from
**Southern
Water**

Your ref
BN/11/22/OUT

Proposal: Outline application with all matters reserved (except for the A29 realignment) for the demolition of existing structures and mixed use development to provide up to 1,250 residential dwellings (use class C3), care home/senior living accommodation (use class C2/C3), flexible retail and community floorspace (use classes E/F2/Sui Generis), a primary school plus open space, landscaping, drainage and all other associated ancillary works; and realignment of the A29 and early connection to existing A29 including construction of a new road carriageway, junctions and associated infrastructure. This application also lies within the parish of aldingbourne, affects the setting of listed buildings, affects the character & appearance of the eastergate church lane conservation area and affects a public right of way. This application is the subject of an Environmental Statement.

Site: BN/11/22/OUT: - Barnham, Eastergate, Westergate BEW Parcel SC1 Barnham.

Appendix F Foul Water Drainage Strategy

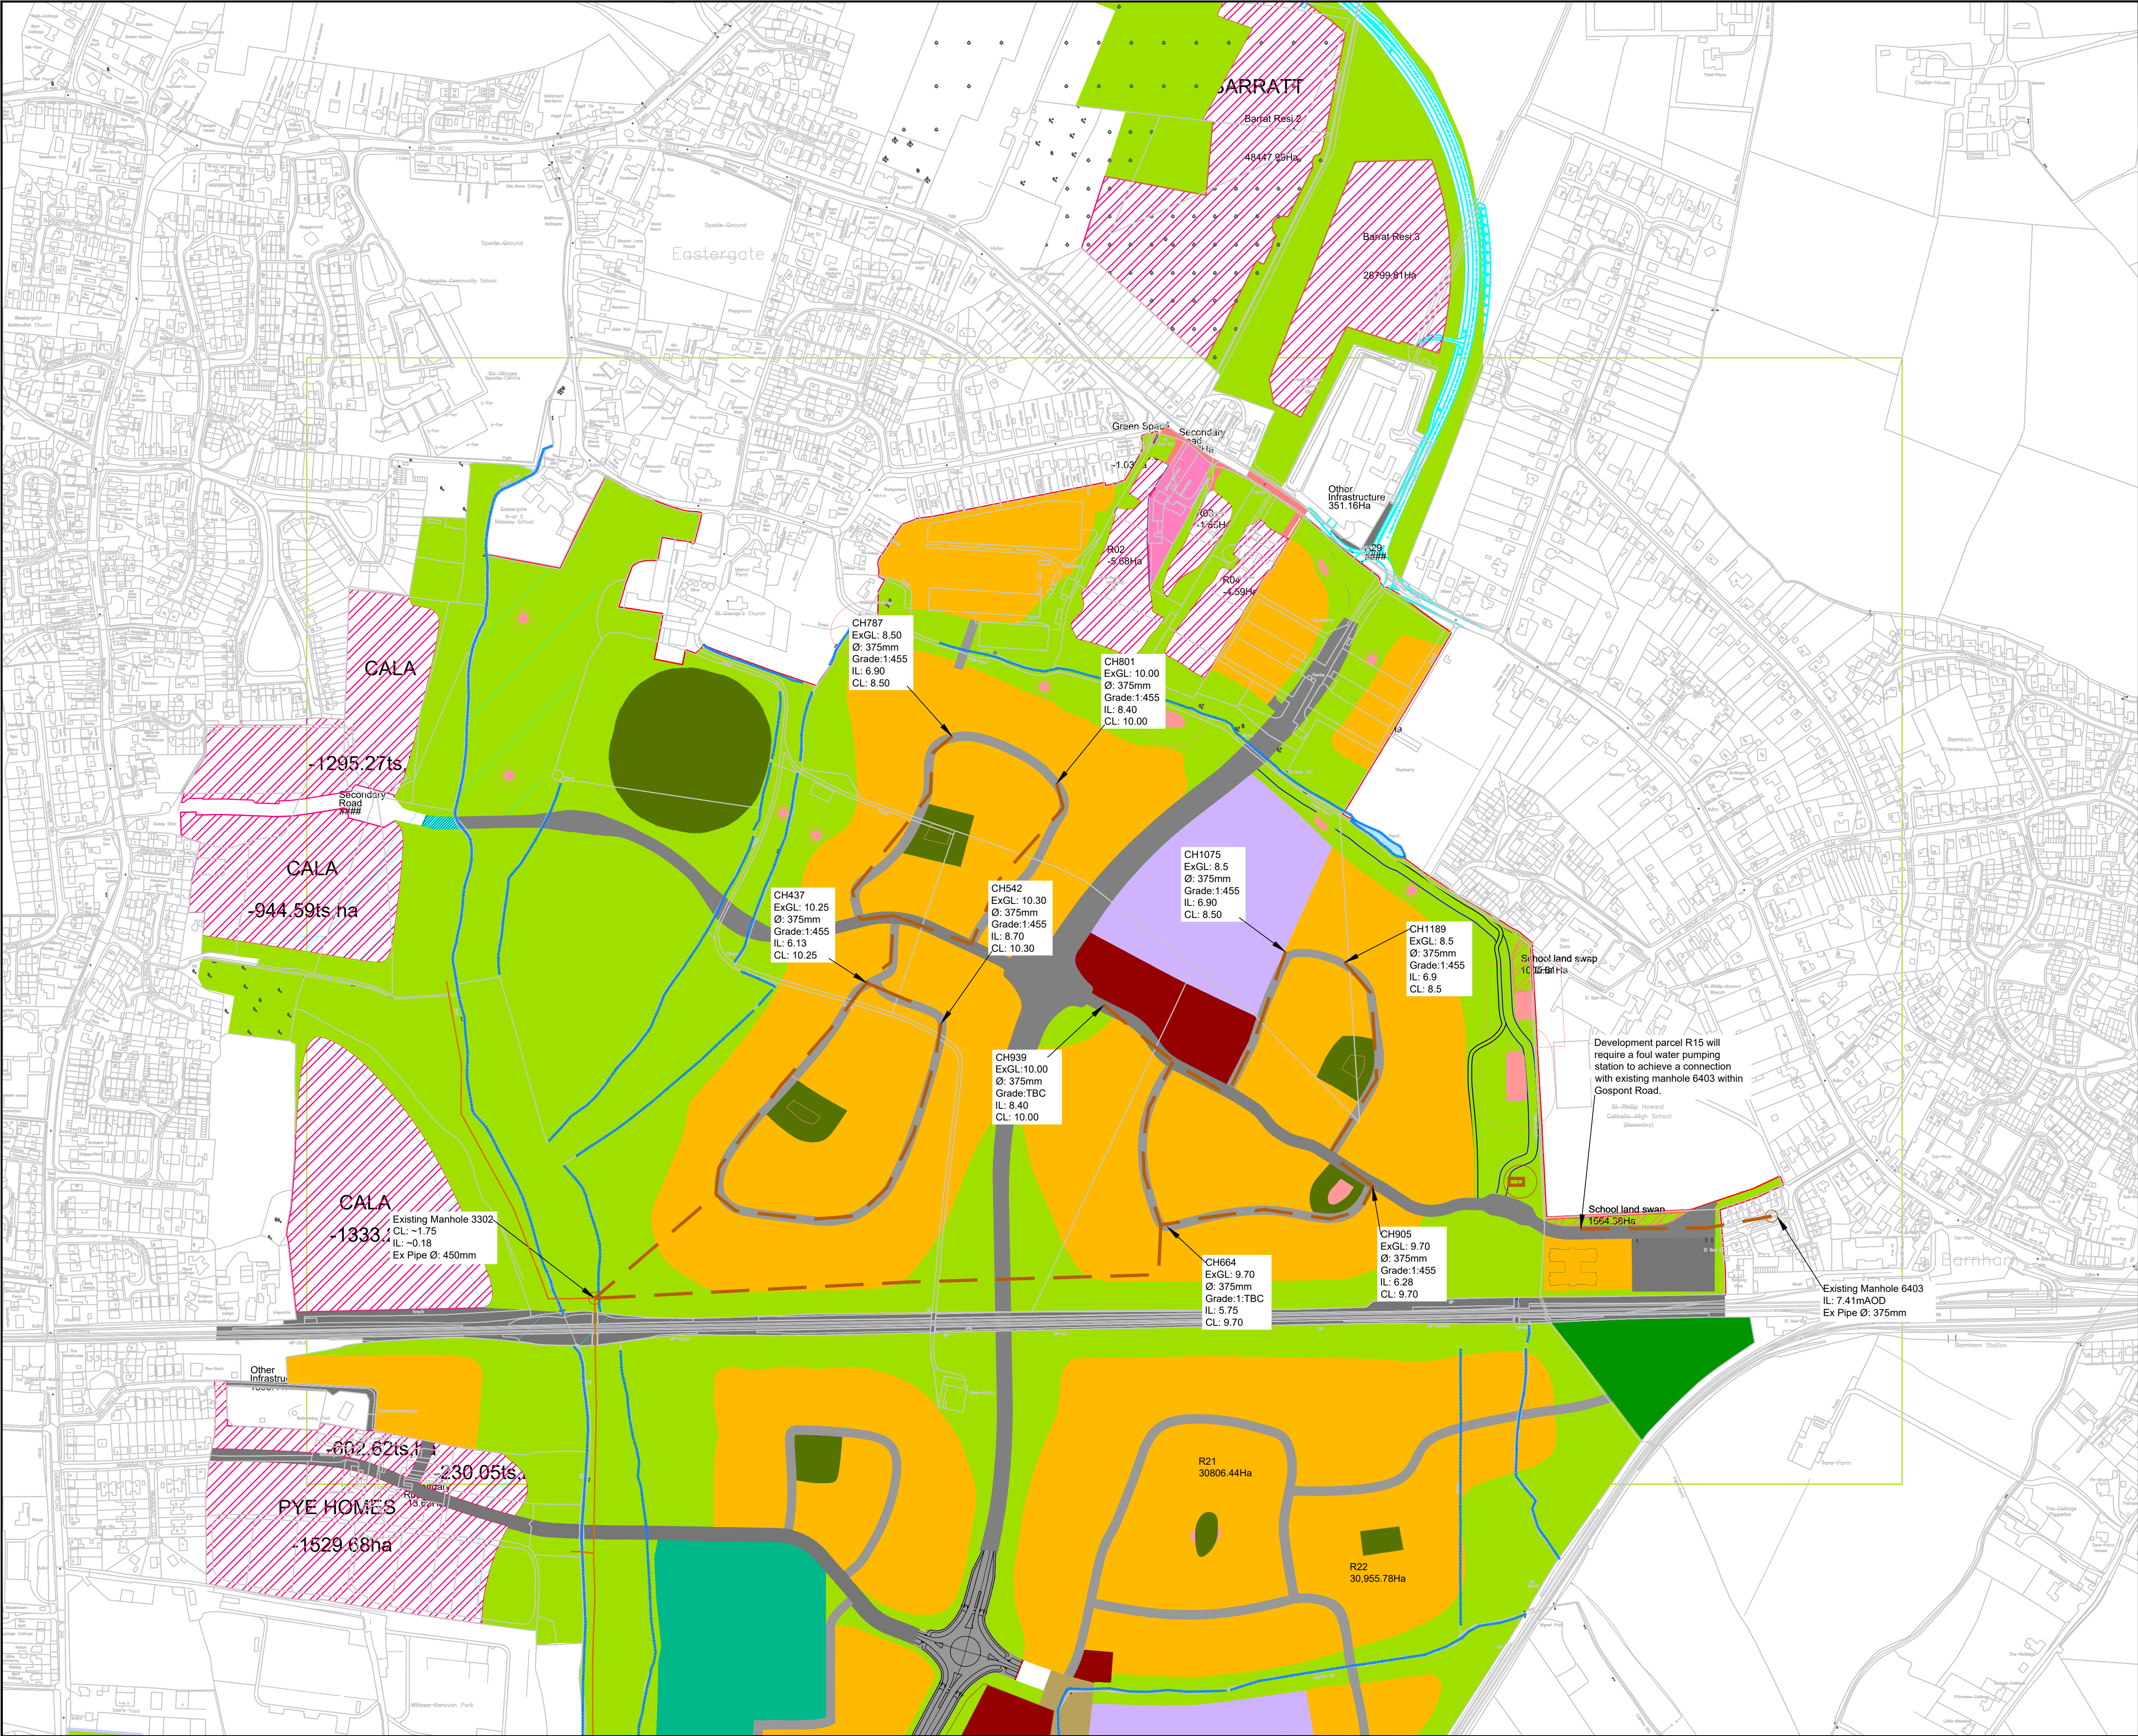
No discharge of foul sewerage from the site shall be discharged into the public system until offsite drainage works to provide sufficient capacity within foul network to cope with additional sewerage flows are complete. Southern Water is currently in process of designing and planning delivery of offsite sewerage network reinforcements. As previously advised Southern Water seeks to limit the timescales to a maximum of 24 months from a firm commitment of the development.
